REPORT UPDATE

Application No: BE/47/09/

LOCATION: Chalcroft Nursery & Associated Land
Chalcroft Lane
Bognor Regis

PROPOSAL: Outline Application for the demolition of all existing buildings and redevelopment of the site with up to 70 dwellings (up to 28 Affordable), public open space and strategic landscaping. Departure from the Development Plan

Scale	1:1000	Drawn By	SAJ	Checked By	CMB	Approved By	PMR
Drawing No.	2009/1046/001	Date	June 2009	Rev.	A

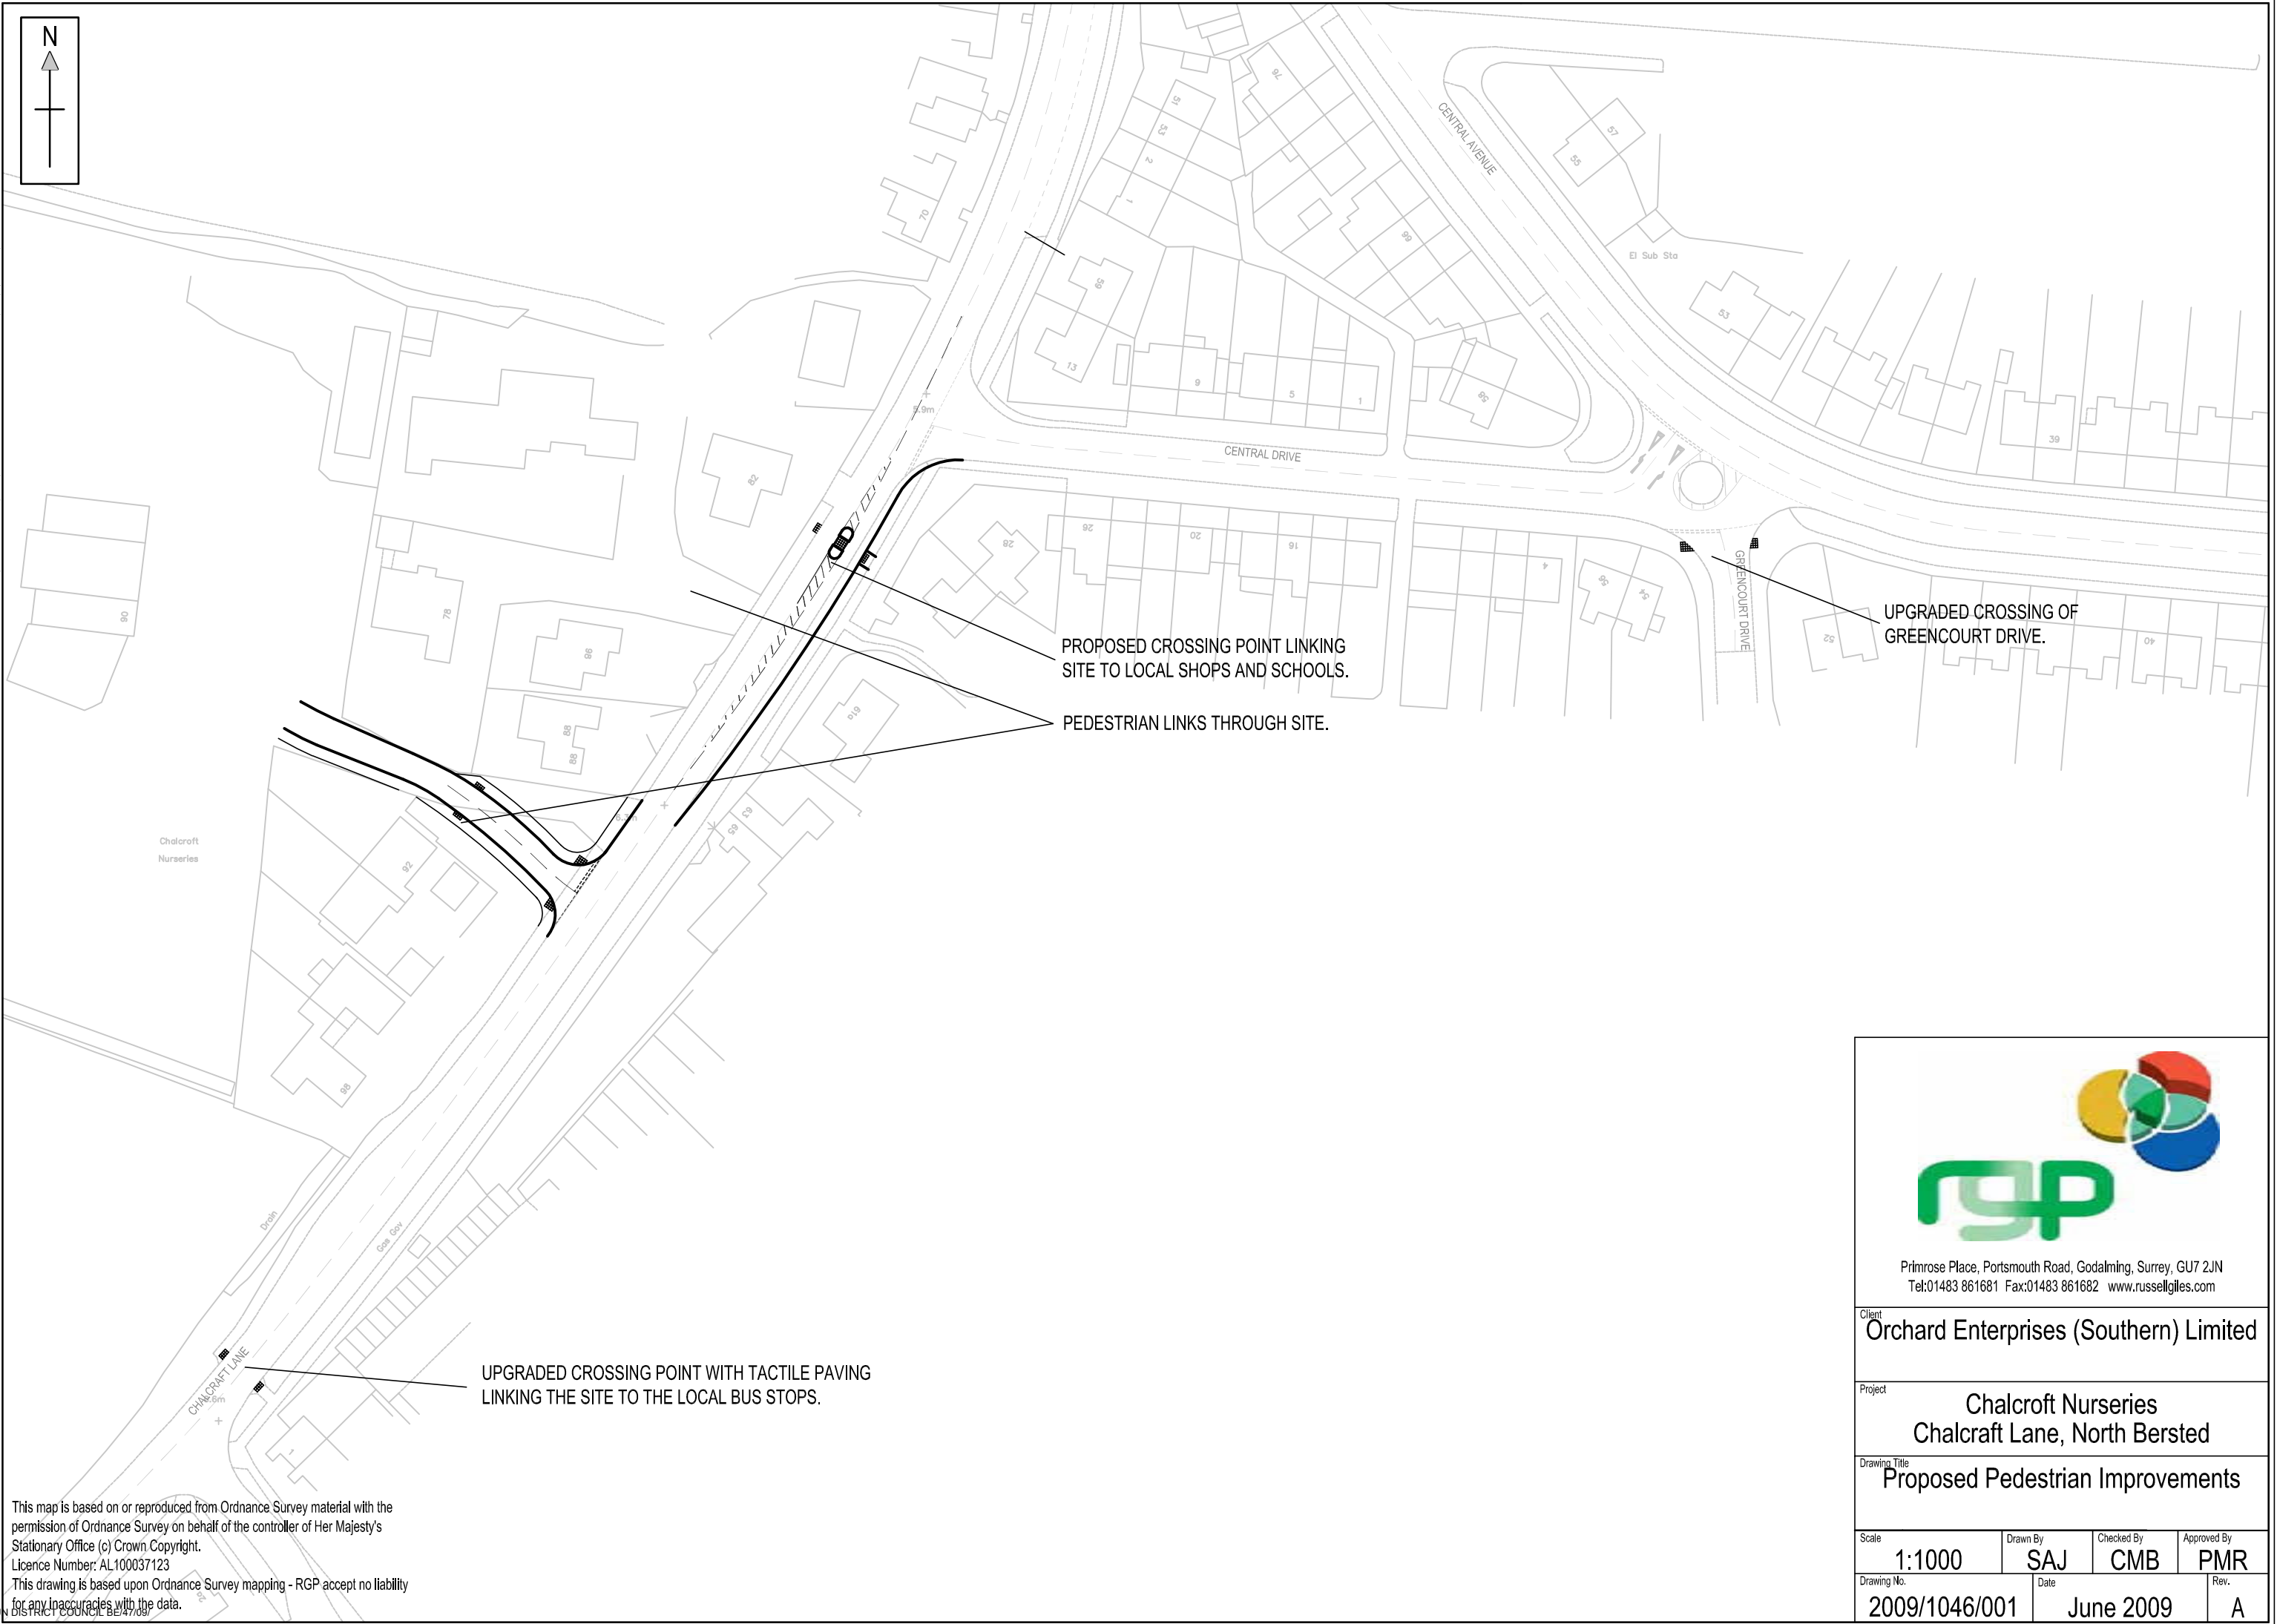
Acknowledging the existing garden centre use on the site and the developer will be providing through a Section 278 agreement pedestrian accessibility improvements to the site, as shown on drawing number 2009/1046/001, it would be reasonable for the developer to make a modest contribution of 50,000 pounds towards sustainable transport improvements that would improve accessibility to the site. The contribution to be paid upon commencement of the development.
